Sandford, 1 Brady Close, EX17 4LQ

Thank you for your recent message regarding the re-submission of plans for the proposed development at 1 Brady Close, Sandford.

I have reviewed my site notes and proposed elevations for the scheme (Drawing No.1566.1-04B) and confirm that my survey report of May 26th 2021 is still valid for the purposes of this re-application.

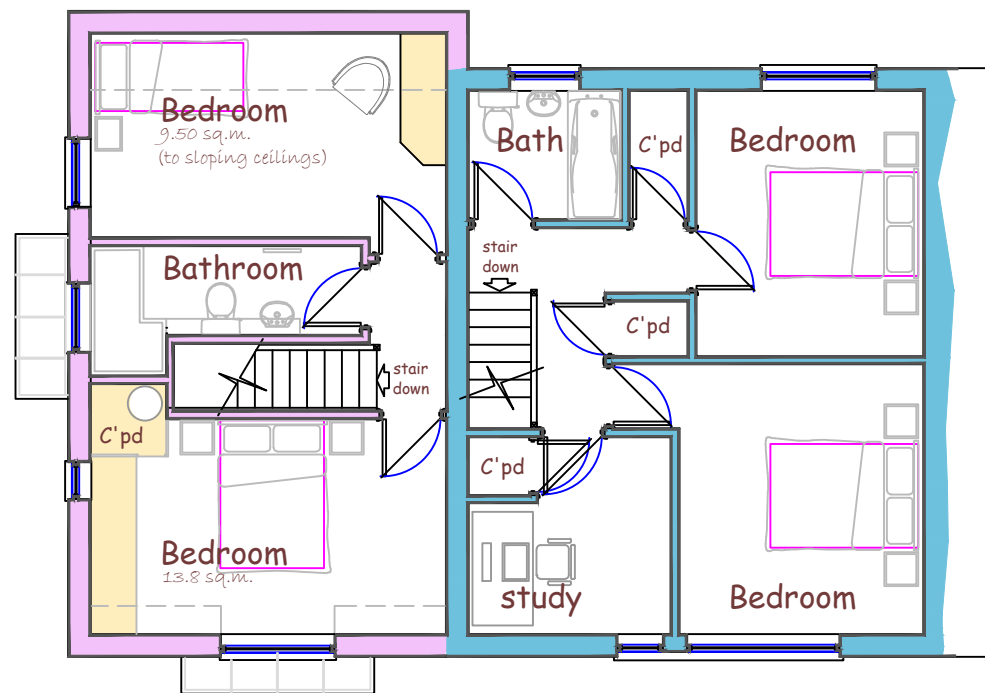
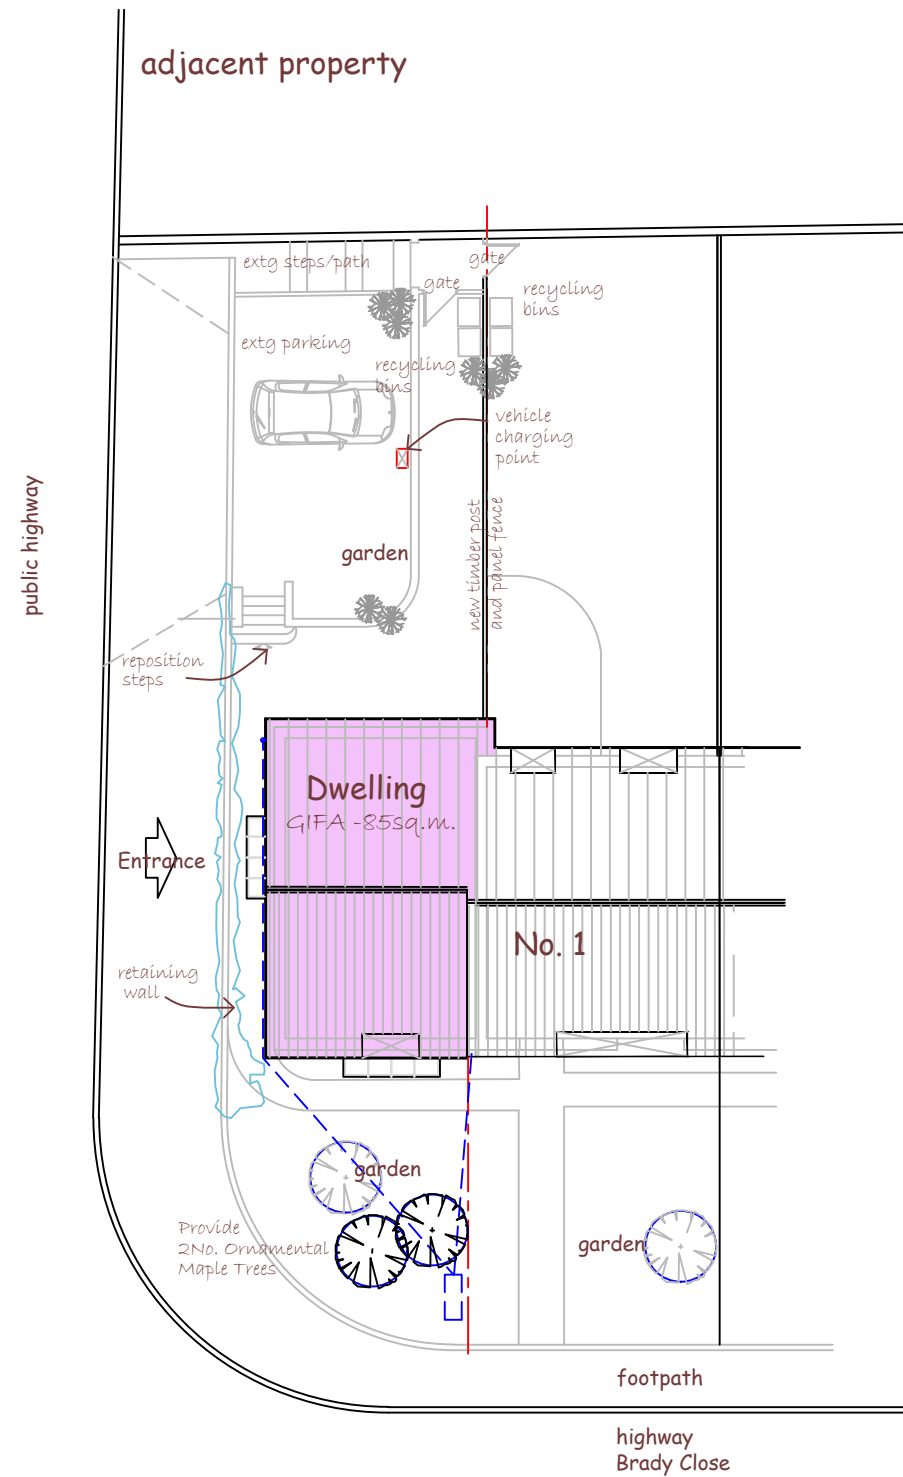
I would also encourage the provision of two trees on the lawns to the west of the current dwelling and proposed dwelling, as per the proposed site layout 1566.1-03B (perhaps of an ornamental maple-type) to provide additional green infrastructure and net gain for biodiversity.
